**Subject:** Eagle Rising SF2225 Plat Filing 1 Response Letter and EDARP Upload

Our responses to the EPC June 6, 2024 Plat and related documents review comments and the Applicant Team/EPC June 24<sup>th</sup> and July 11<sup>th</sup> review meetings have uploaded EDARP.

CIVIL CONSULTANTS, INC.
 212 N. WAHSATCH AVE., STE 305
 COLORADO SPRINGS, CO 80903
 PHONE: 719.955.5485
 SHEET 2 OF 5

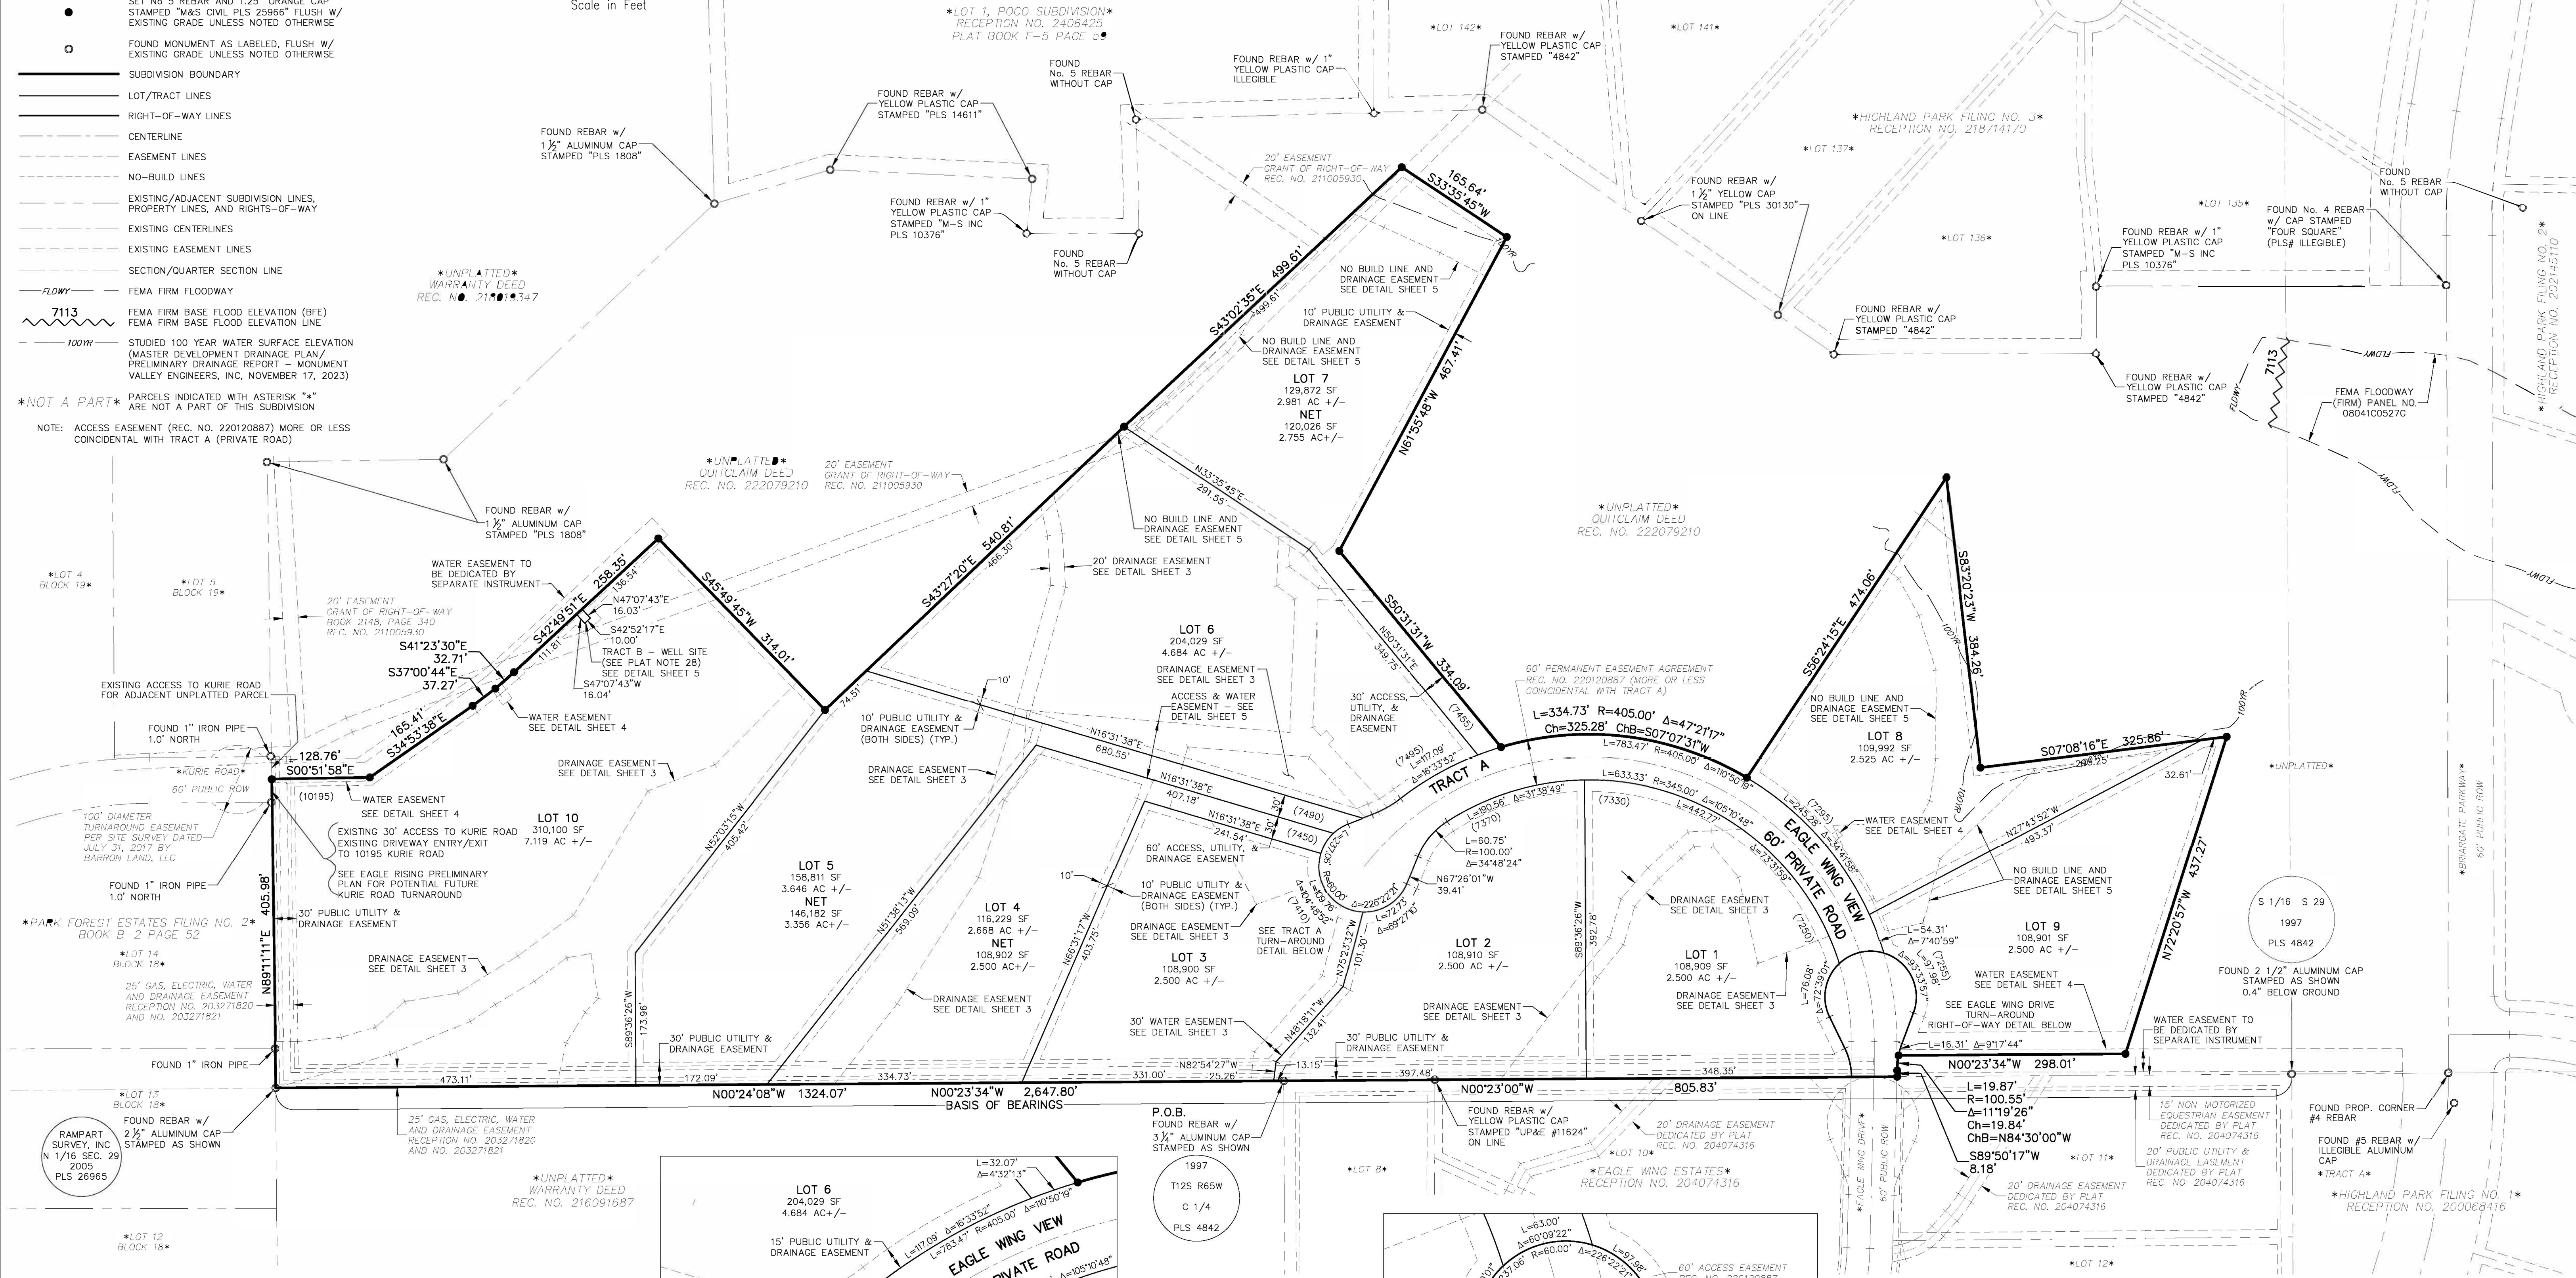
12	Final Plat Eagle Rising Filing No 1	PCD Engineering Division	Yes	Edward Schoenheit	6/6/2024 10:39	(Plat redlines)	1	There is no record of driveway permits. Eagle Wing is the now designated private road 10195 Kurie Drive has no permit on file. Provide permit #s or delete the highlighted portion.	E - Answer provided	7/30/2024	Final Plat Eagle Rising Filing No 1	-	Driveways currently exist for 10195 Kurie Drive and 7495 Eagle Wing Drive.		
13	Final Plat Eagle Rising Filing No 1	PCD Engineering Division	Yes	Edward Schoenheit	6/6/2024 10:39	(Plat redlines)	1	Add note if individual lot owners will be responsible for culvert construction and driveway grading: Lots 3, 4, 5, 6, and 7 require engineered site plans for installation of culverts, grading, and easements as applicable.	E - Answer provided	7/30/2024	Final Plat Eagle Rising Filing No 1	-	New EPC comment not stated in any previous review Modified Note 16: "Individual lot owners are responsible for any necessary driveway culvert construction and driveway grading." "If all owners of lots 3,4,5,6 agree to fill pond for driveways, engineering consultation recommended. Access to lots 4,5,7 provided by access easement over lot 6."

14	Final Plat Eagle Rising Filing No 1	PCD Engineering Division	Yes	Edward Schoenheit	6/6/2024 10:39	(Plat redlines)	1	Provide the fee values	A - Approve	7/30/2024	Final Plat Eagle Rising Filing No 1	1	See Fees block		
15	Final Plat Eagle Rising Filing No 1	PCD Engineering Division	Yes	Elizabeth Nijkamp	6/6/2024 10:39	(Plat redlines)	1	See comment letter for additional comments.	E - Answer provided	7/30/2024	Final Plat Eagle Rising Filing No 1	-	Comments on the Final Plat Redlines are addressed on the redline items and all responses to county comments.		
16	Final Plat Eagle Rising Filing No 1	PCD Engineering Division	Yes	Ryan Howser	6/6/2024 10:39	(Plat redlines)	2	This note is not adequate per LDC Sec. 8.4.4.B which states that either public ROW is dedicated, or land for public ROW is preserved. You must depict the land for dedication or preservation for future ROW, per the discussion staff had with the applicant.	E - Answer provided	7/30/2024	Final Plat Eagle Rising Filing No 1	1	See Plat Note #28 "WHEN FOUR OR MORE LOTS ACCESS KURIE ROAD, A TURNAROUND IS REQUIRED TO BE CONSTRUCTED AS SHOWN ON THE PRELIMINARY PLAN." See May 21, 2024 Letter and July 26, 2024 Letter "RE: Eagle Rising Final Plat Filing No. 1 (Minor) SF2225: Existing Driveway Access to Existing Kurie Road via existing platted permanent turnaround"

18	Final Plat Eagle Rising Filing No 1	PCD Engineering Division	Yes	Edward Schoenheit	6/6/2024 10:39	(Plat redlines)	2	Right-of-Way Dedication Required. Roads shall be located within a dedicated public right-of-way meeting the requirements of the ECM for the roadway classification proposed. .... In accordance with BoCC policy, the BoCC may allow a disclosure such as "public ROW easement" or "future ROW" to be placed on a plat as an alternative to dedication. If you choose to not provide ROW at this time, and are requesting to instead add a note to call out "public ROW easement" or "future ROW", please add to your LOI to allow the BOCC to make this allowance, also add this call out and the easement area to the plat. A "NEPE" easement document will be required if this option is allowed by the BoCC.	E - Answer provided	7/30/2024	Final Plat Eagle Rising Filing No 1	-	<p>Not required.</p> <p>El Paso County's proposed exaction is a violation of Colorado RIPRA statute C.R.S. § 29-20-203.</p> <p>See May 21, 2024 Letter and July 26, 2024 Letter "RE: Eagle Rising Final Plat Filing No. 1 (Minor) SF2225: Existing Driveway Access to Existing Kurie Road via existing platted permanent turnaround "</p>

Lot 10 driveway access to Kurie Road is addressed with Plat Note #28 indicating that "When four or more lots access Kurie Road, a turnaround is required to be constructed as shown on the approved Preliminary Plan." Plat Note #16 No additional driveways can be constructed without Owner's Association approval.
